M60/M62/M66 Simister Island Interchange

TR010064

7.18 Statement of Common Ground with Bury Council

Version	Date	Status of Version
P024	15 October 2024 10 January 2025	Examination Deadline 52

FIGURE 5.10

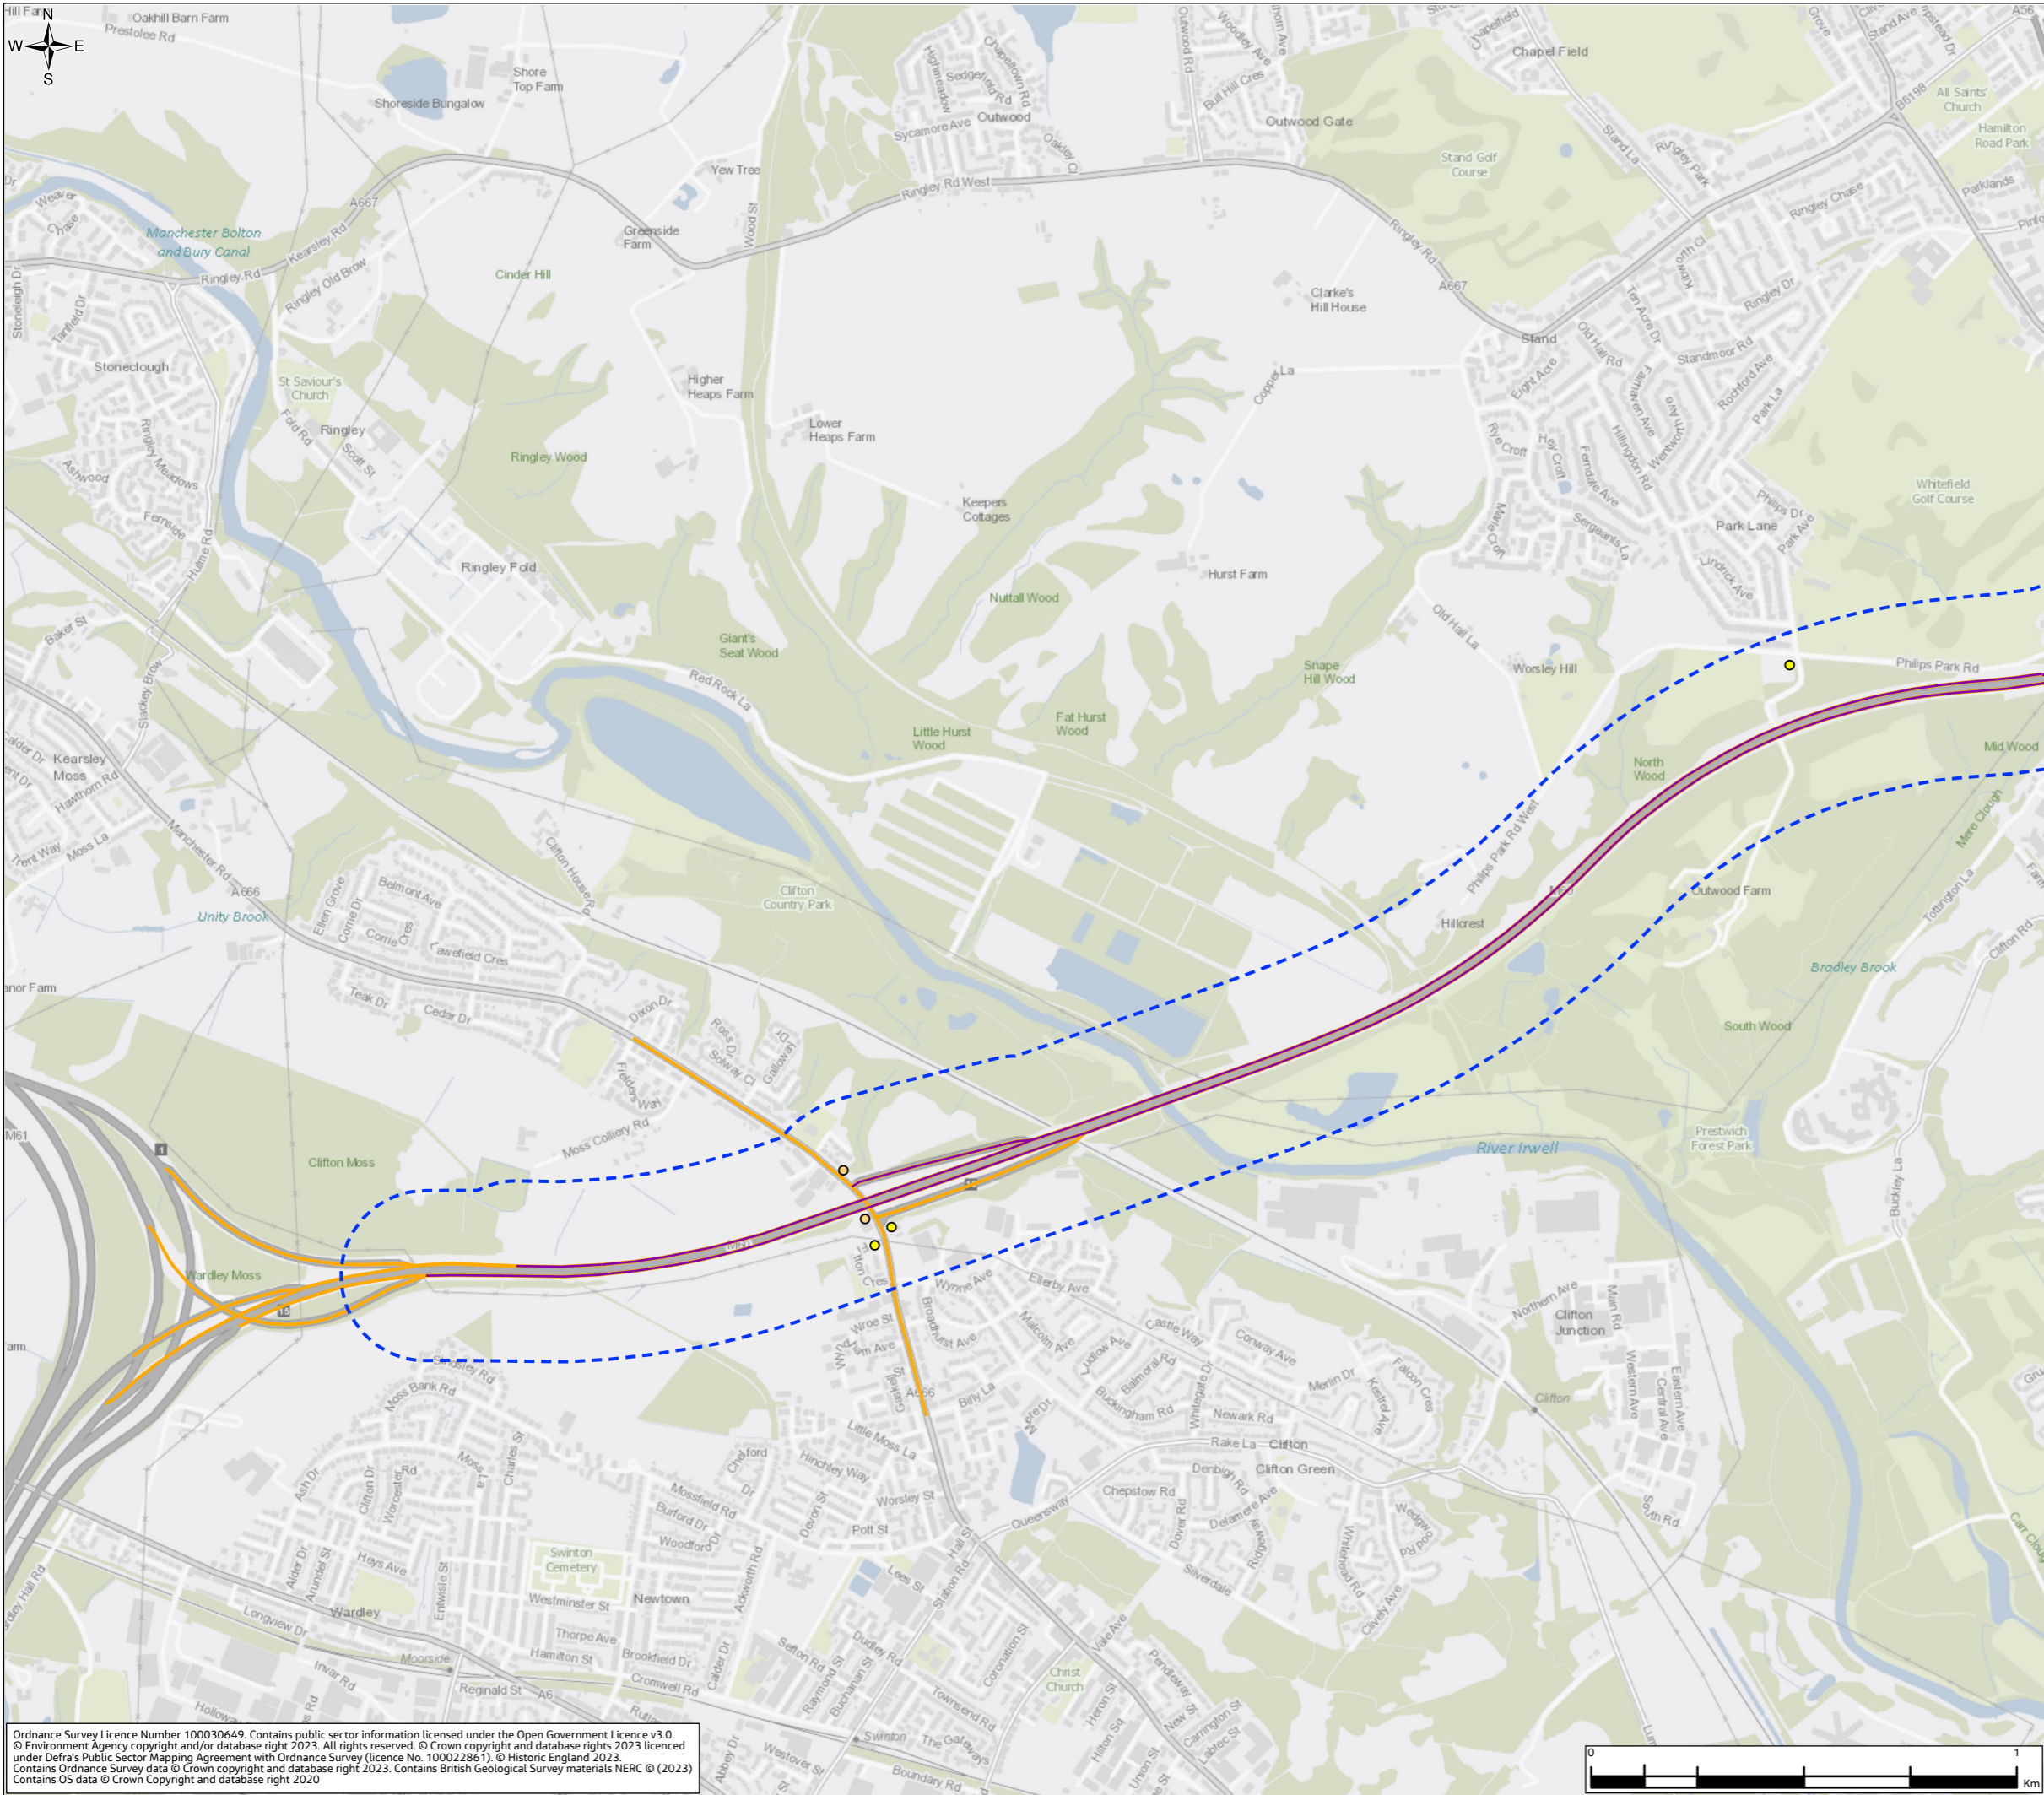
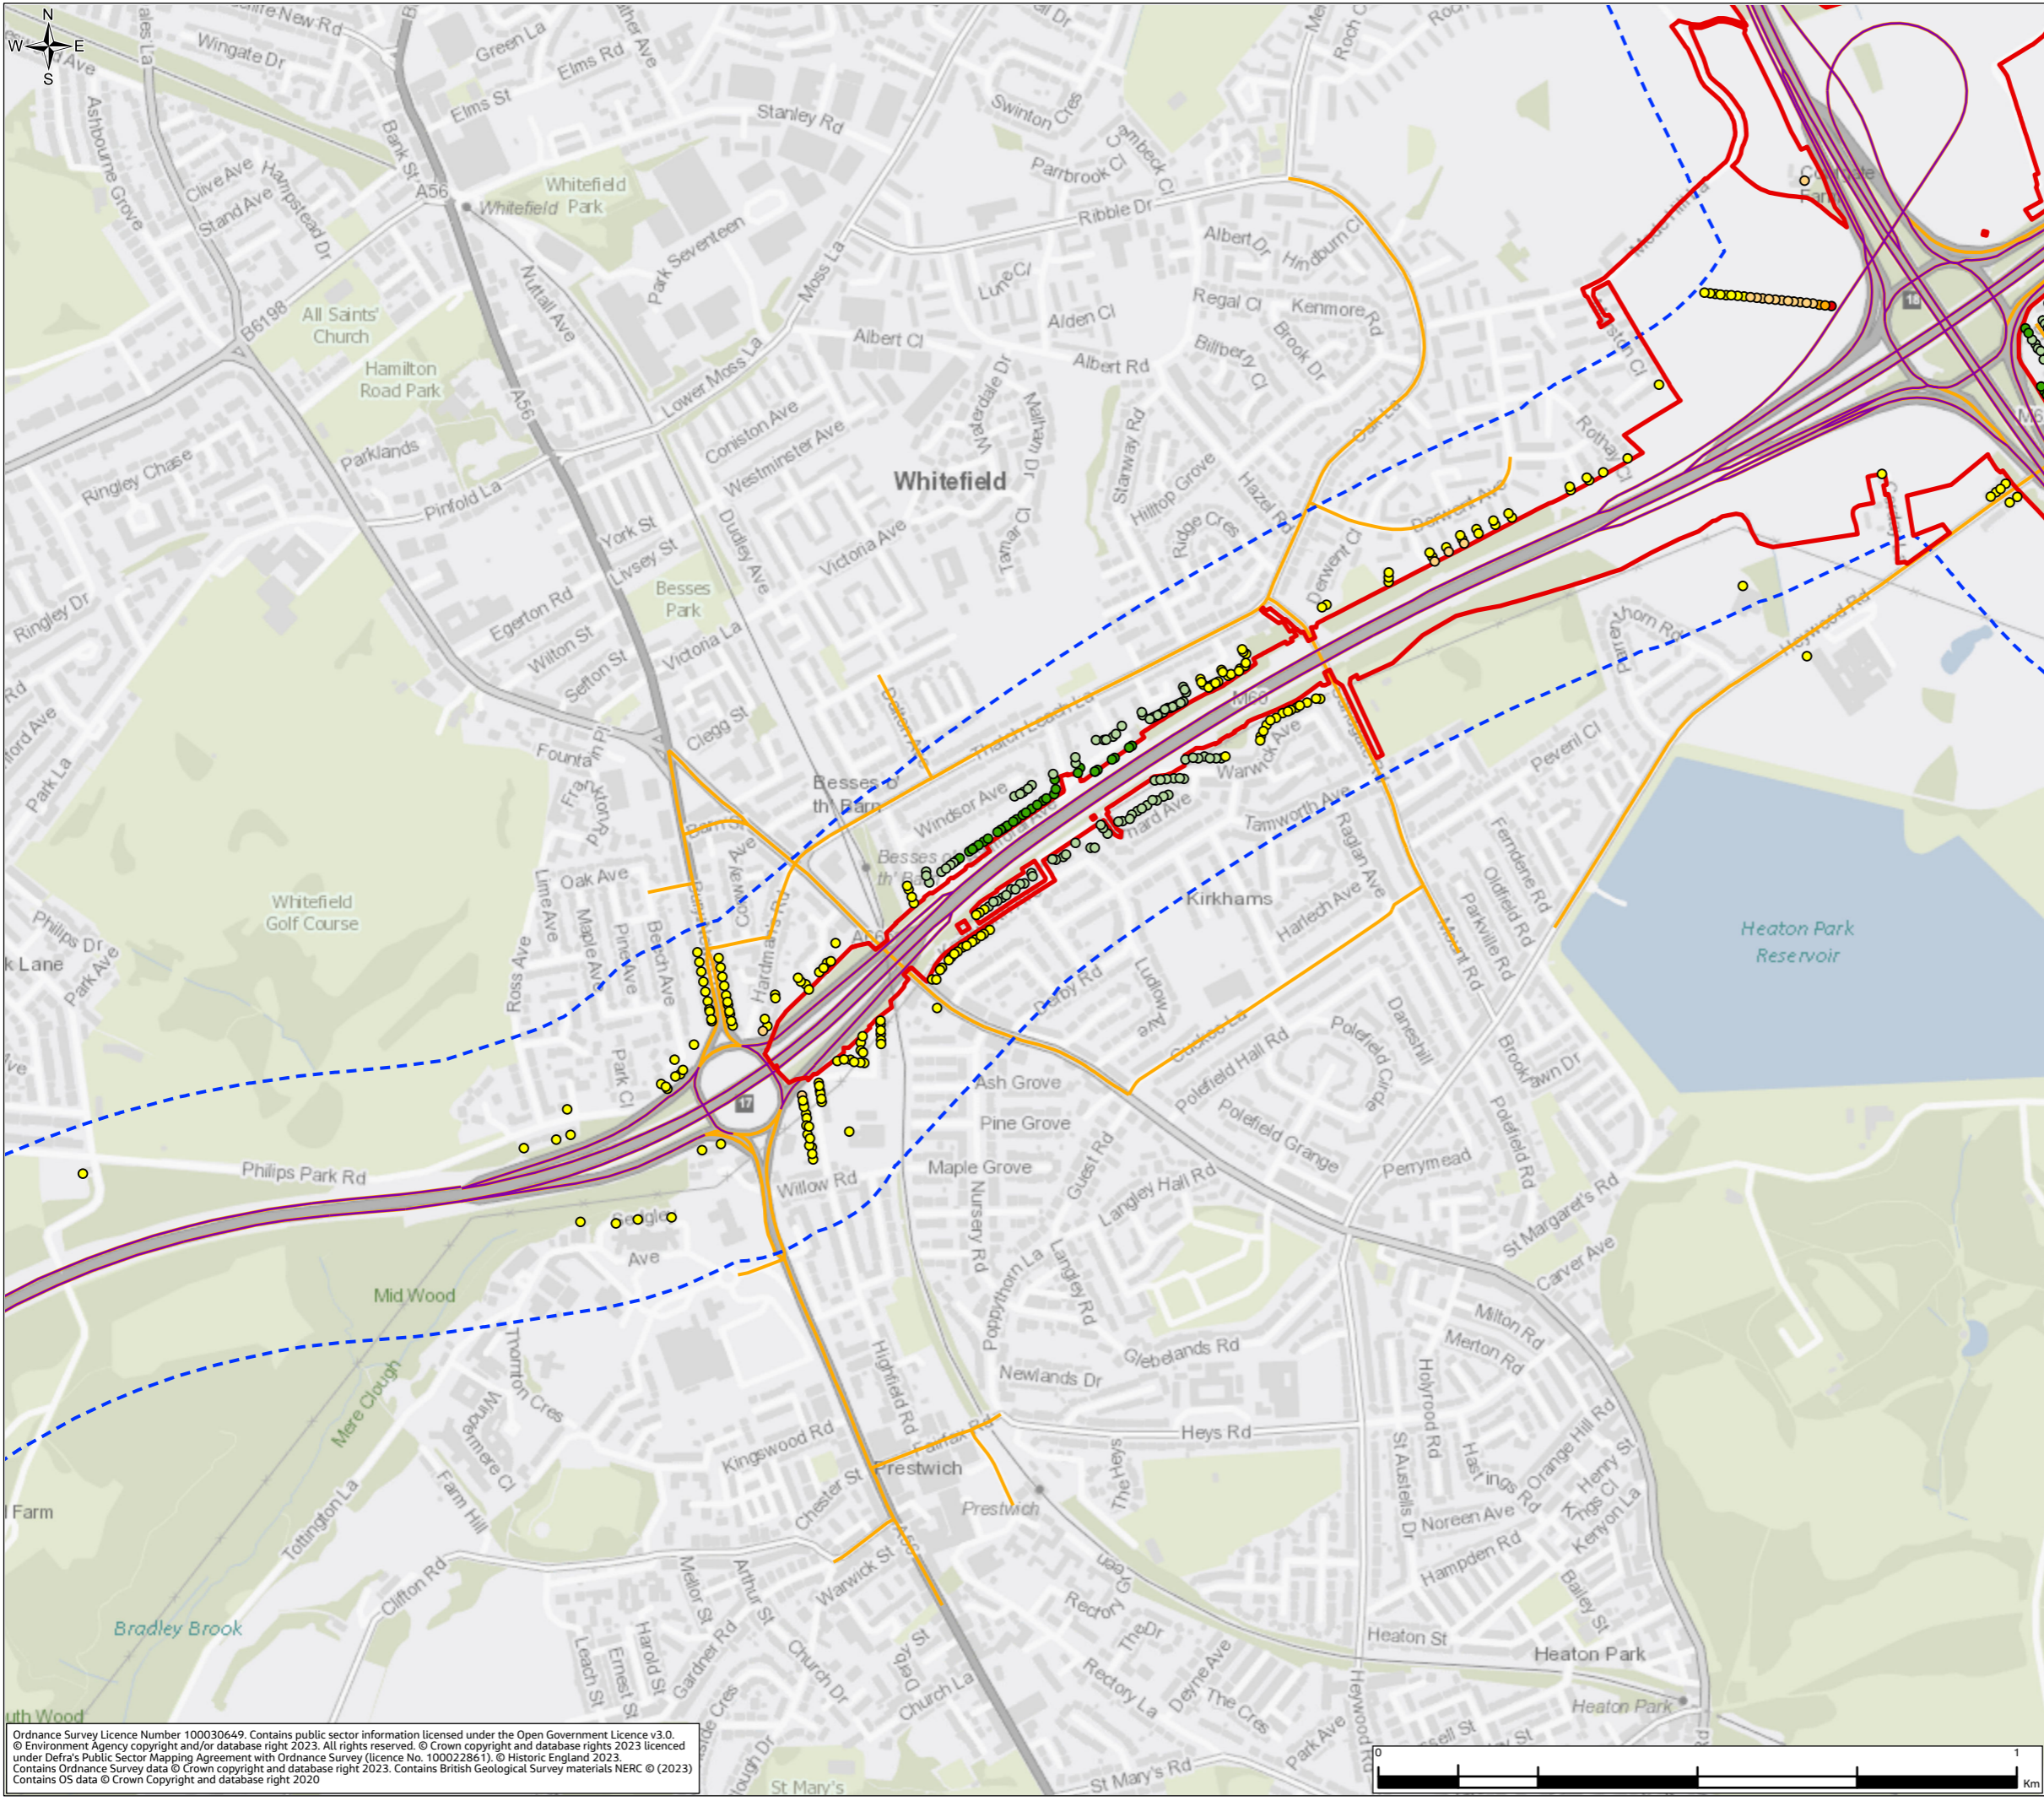
4	Operational Phase Air Quality Impacts	Chapter 5: Air Quality of the Environmental	Bury Metropolitan Borough Council reviewed the results of the operational traffic assessment presented in Appendix 5.2: Air Quality Results [APP-	The Applicant notes Bury Metropolitan Borough Council comments on the findings and conclusions of the	No	Not Agreed	26/09/24

Ref	Issue	Doc Ref	Bury Metropolitan Borough Council Position	National Highways' Position	Agreement Likely	Status	Date
		<p>Statement [APP-045]</p> <p>Appendix 5.2: Air Quality Results [APP-080] of the Environmental Statement Appendices</p> <p>Chapter 5: Air Quality (Figures 5.10-5.11) [APP-061] of the Environmental Statement Figures</p> <p>draft Development Consent Order [REP1-004].</p>	<p>080] of the Environmental Statement Appendices and Chapter 5: Air Quality (Figures 5.10-5.11) [APP-061] of the Environmental Statement Figures. Based on the information provided, the findings and conclusions of the operational phase traffic risk assessment appear reasonable.</p> <p>Bury Metropolitan Borough Council note that the assessment concludes that the operational phase will improve air quality. In order to demonstrate that the predicted improvements in air quality have been achieved, A programme of air quality monitoring (for NO2) should be undertaken once the Scheme is operational to demonstrate that the predicted improvements in air quality have been achieved.</p> <p>Bury Metropolitan Borough Council notes the Applicant's position that there are no identified significant effects for air quality for the Scheme, as set out in paragraph 5.11.1 of the Chapter 5 Air Quality of the Environmental Statement [APP-044], there is no requirement to undertake future air quality monitoring where the assessment concludes no significant effects.</p> <p>Bury Metropolitan Borough Council also notes that the traffic flow monitoring to be carried out as part of the Post</p>	<p>operational phase traffic risk assessment.</p> <p>Chapter 5 Air Quality of the Environmental Statement [APP-044] discusses the air quality assessment and concludes that there would be no significant effects, due to air quality, during construction and operation of the Scheme from road traffic changes. The assessment of significant effects is based on the Design Manual for Roads and Bridges (DMRB) LA 105 (Air quality) definitions, which are explained in Chapter 5 Air Quality of the Environmental Statement [APP-044]. Closer to the Scheme, between M60 junction 17 and M60 junction 18 and around Simister, there is generally a reduction in air pollution concentrations (i.e., an improvement in air quality) with the Scheme in place. This reduction is due to either reduced congestion between M60 junction 17 and M60 junction 18 or, for Simister, due to traffic using the Northern Loop slip road (i.e., some traffic is moved further away).</p> <p>In response to Bury Metropolitan Borough Council's request for a programme of air quality monitoring, the Applicant notes that some schemes with predicted significant effects in relation to air quality undertake monitoring to</p>

Ref	Issue	Doc Ref	Bury Metropolitan Borough Council Position	National Highways' Position	Agreement Likely	Status	Date
			<p>Opening Project Evaluation (POPE) process to determine whether predicted flow rates were realistic could also be used to assess whether the predicted air quality impacts were accurate. However, we still consider that carrying out a programme of diffusion tube (NOx) monitoring would be a positive action to demonstrate to concerned local residents that local air quality had not been significantly worsened by the Scheme and that the predicted impacts of the Scheme were accurate. It is understood that the Applicant already monitors in certain locations within the vicinity of the motorway network and we do not consider that the extending this diffusion tube monitoring network would be an onerous requirement. This issue is not agreed.</p>	<p>assess compliance against Air Quality Objectives and/or Limit Values. However, as discussed in paragraph 5.11.1 of the Chapter 5 Air Quality of the Environmental Statement [APP-044], as there are no identified significant effects for air quality for the Scheme, there is no requirement to undertake future air quality monitoring. It should be noted that it is very difficult to prove the impact of a scheme, by itself, on air quality by monitoring future air quality. This is due to the typical year-to-year variations that occur due to differing conditions such as wind speed and direction, as well as year to year changes in vehicle emissions, which are changes not related to the Scheme. Typically, the impact on air quality from a scheme is assessed under the Post Opening Project Evaluation (POPE) process, which is undertaken on all major road schemes once it has been operational for one year and again 5 years post-opening. Other schemes under POPE have used monitored road traffic flows and speeds before and after a scheme is opened, to calculate a scheme-only change to emissions which are due to changes in traffic (as opposed to air quality changes due to metrological conditions or changing vehicle emissions).</p>
